27 October 2025

Re: Canterbury Bankstown City Council Submission to the State Significant Development Application, SSD-83256463 – 150 The Boulevard and 34 Dudley Street, Punchbowl, Punchbowl, Homes NSW Affordable Housing Development

Attachment A - Summary of Additional Information, Amendments and Recommended Conditions of Consent Requested by Council

Attachment B - Detailed Comments

1 Communal Open Space - Ground Floor
1:200

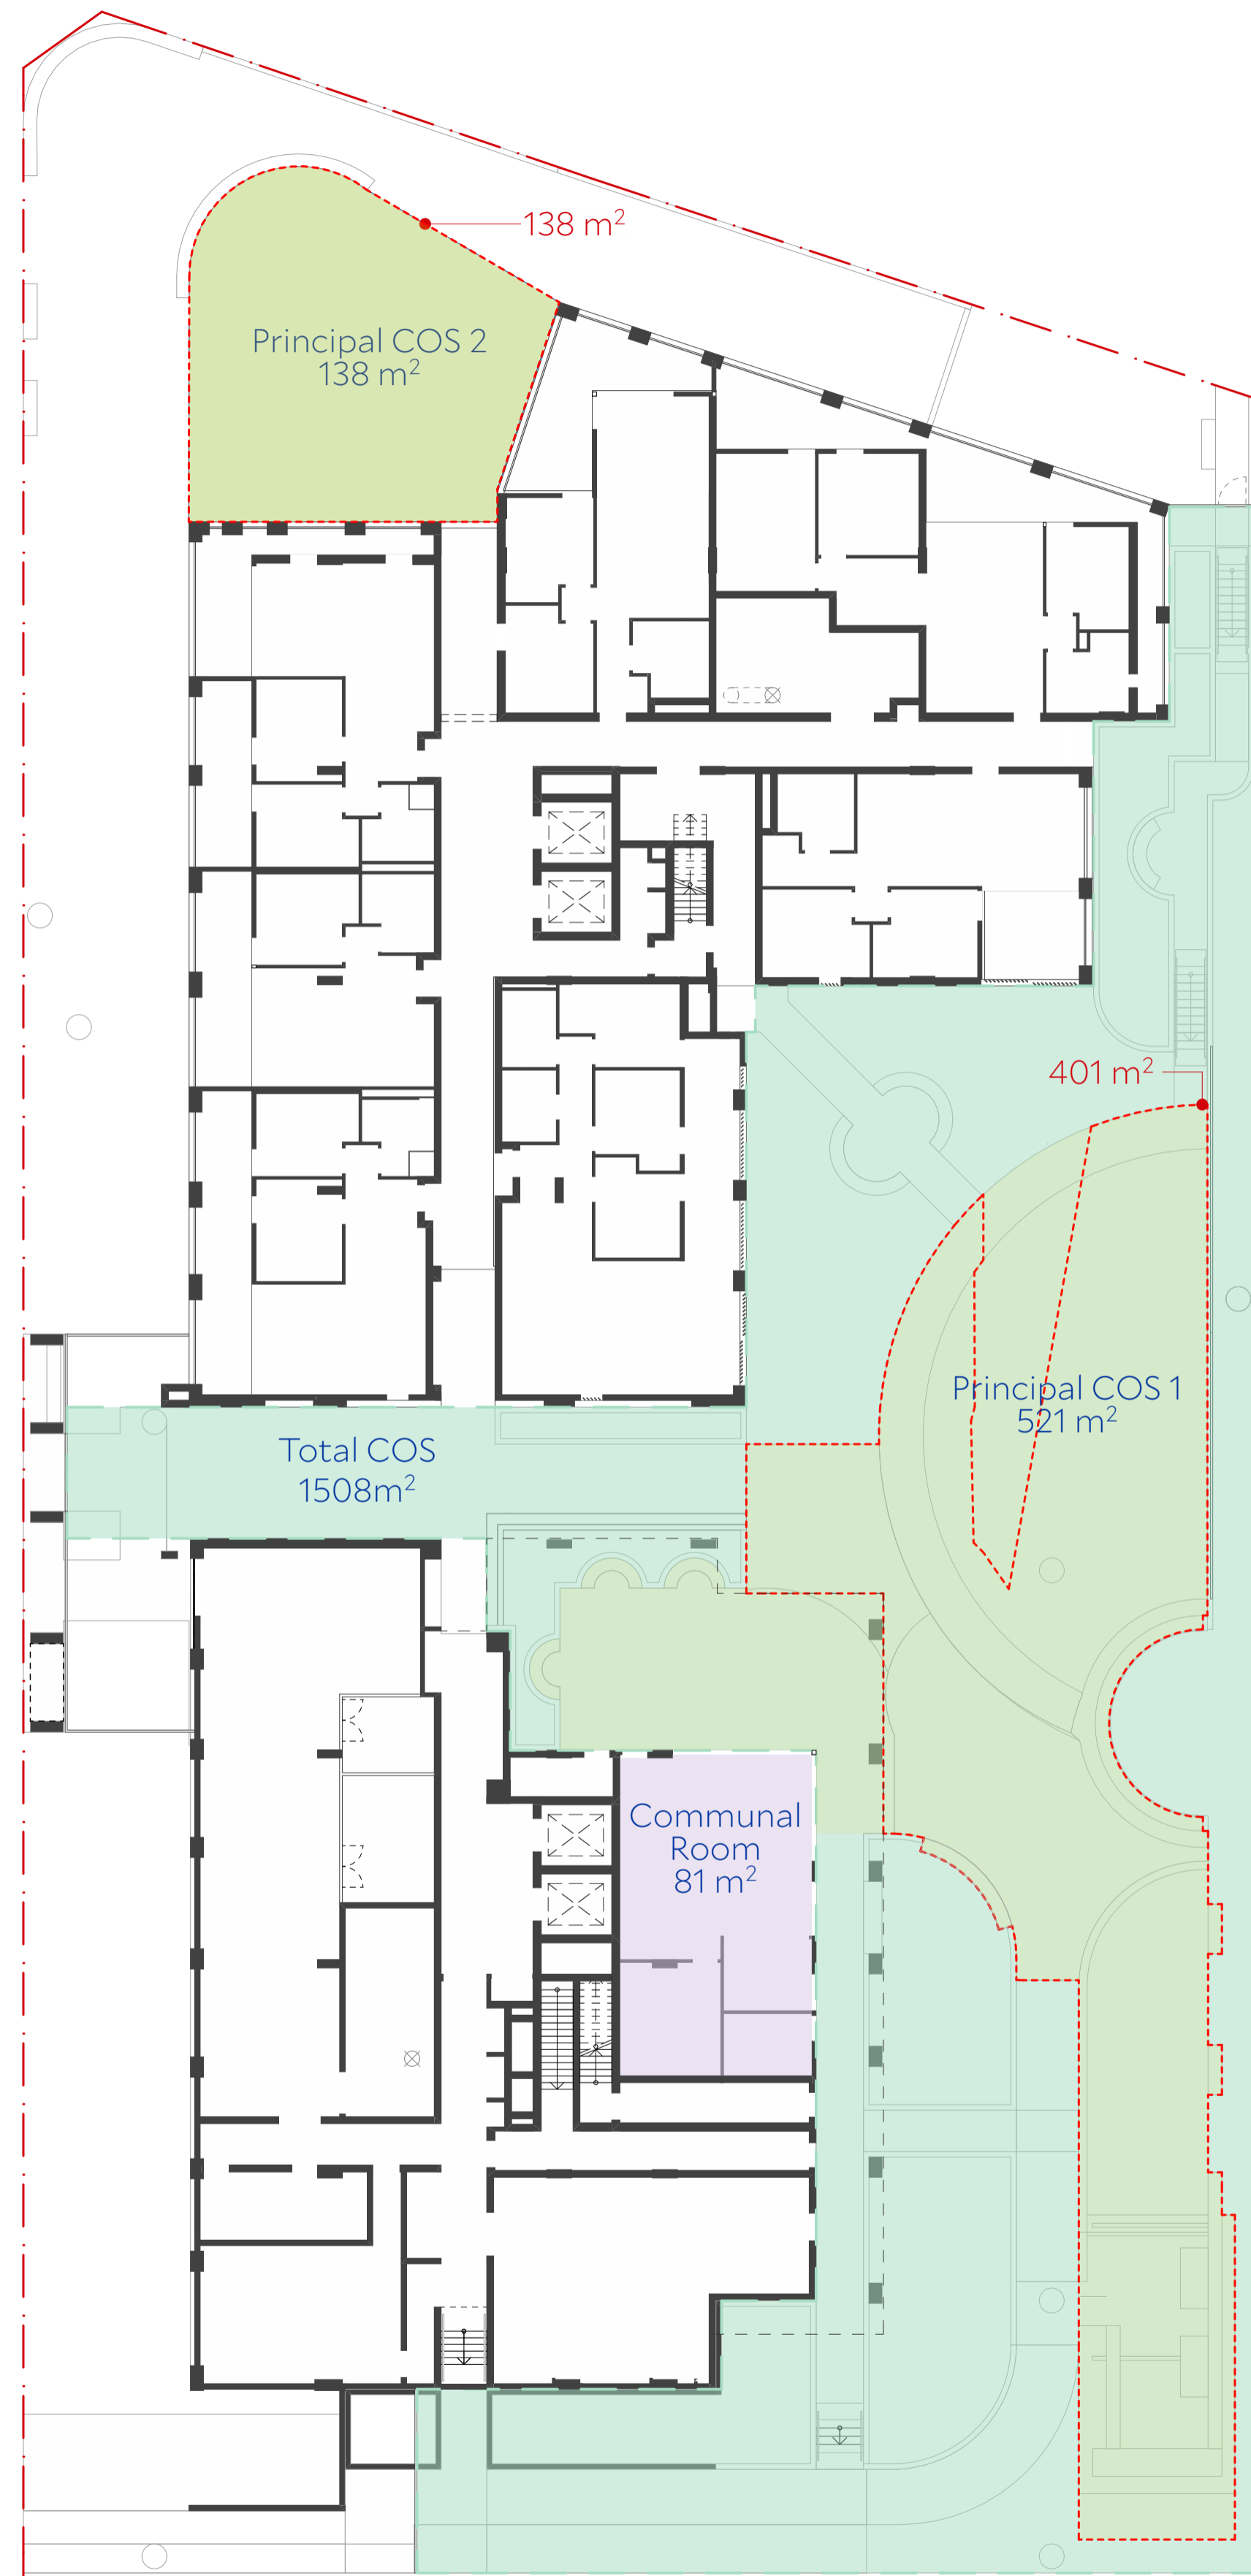
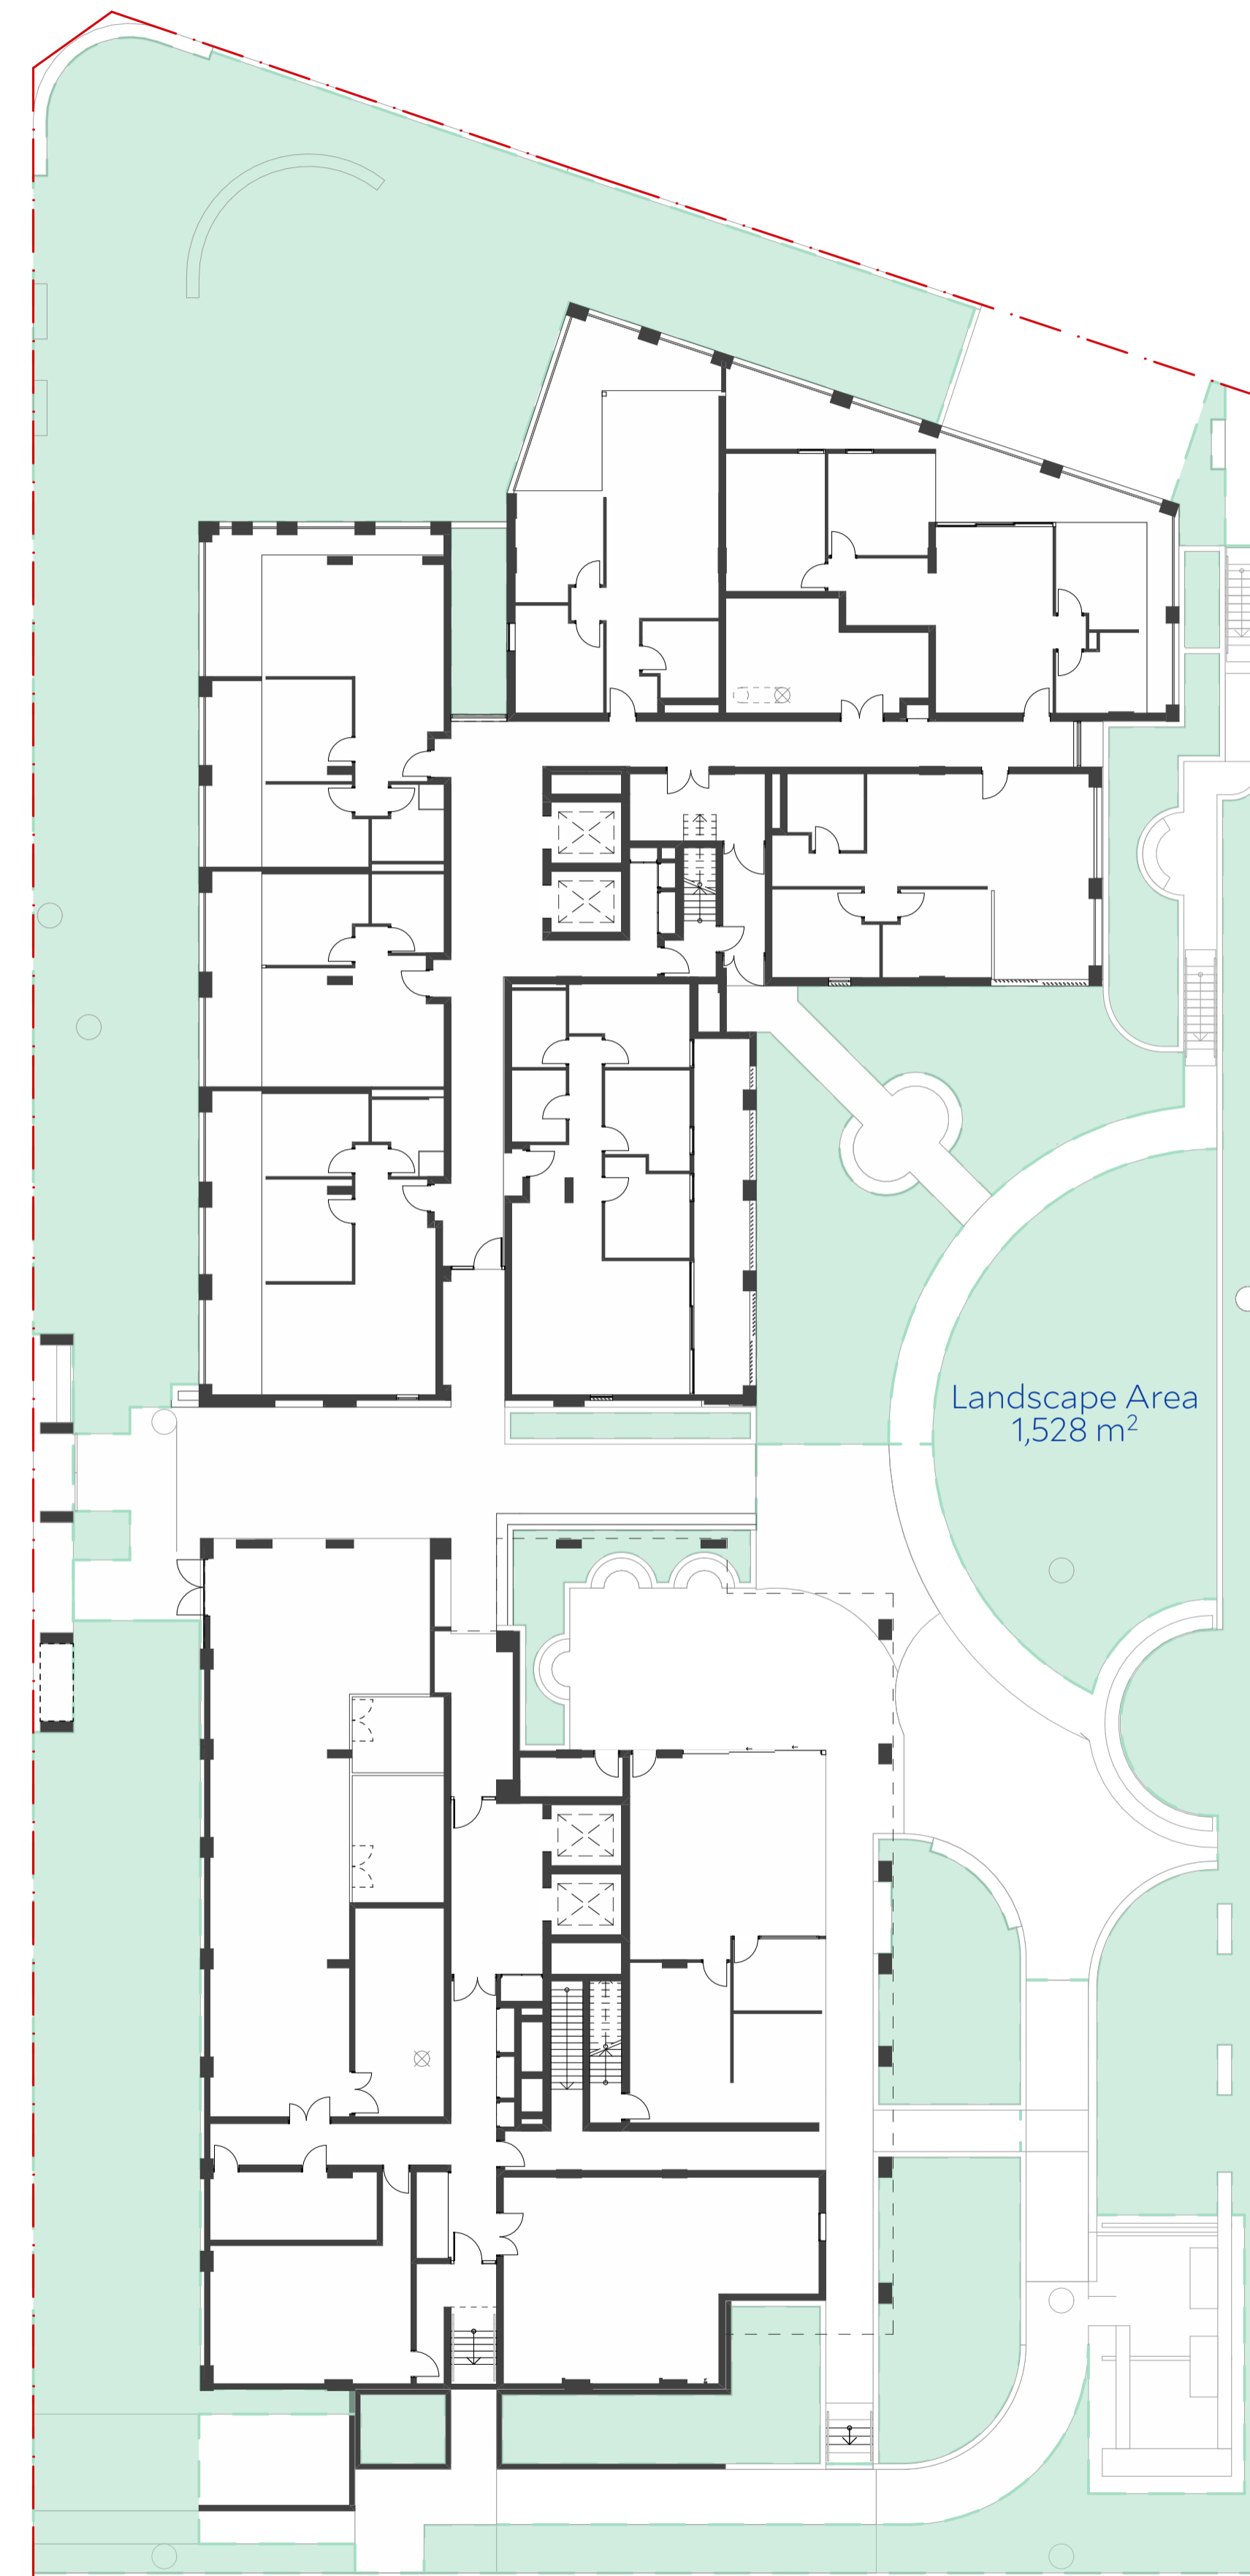
Category	Council Feedback
	the presence of the proposed shelter, this constrains the growth of large trees such as the proposed species. <u>Recommendation:</u> the proponent shift the BBQ and shelter further north to increase the garden-bed width to a minimum of 2m, and replace the proposed trees with smaller species such as <i>Elaeocarpus reticulatus</i> 'pink' or <i>Betula pendula</i> 'fastigiata'.
Strategic Assessments	- As part of the State Government's Transport Oriented Development (TOD) program Council prepared the Punchbowl and Wiley Park Precinct Plan which was adopted by Council and submitted to the Department in late 2024. The LEP Amendments proposed in the Council's adopted Plan are under review by the Department.  Map showing the Council adopted Precinct Plan for Punchbowl and Wiley Park – the subject site is marked in red. - Under the Precinct Plan, the site has a maximum height of 12 storeys. The proposal is limited to 8 storeys, well below the maximum height envisaged by Council. - It is noted that the proposal significantly exceeds the current planning controls for the site under the Canterbury Bankstown Local Environmental Plan 2023 and the applicant is relying on the . Council requests that there is greater planning certainty provided by the Department before any determination is issued for this SSDA.
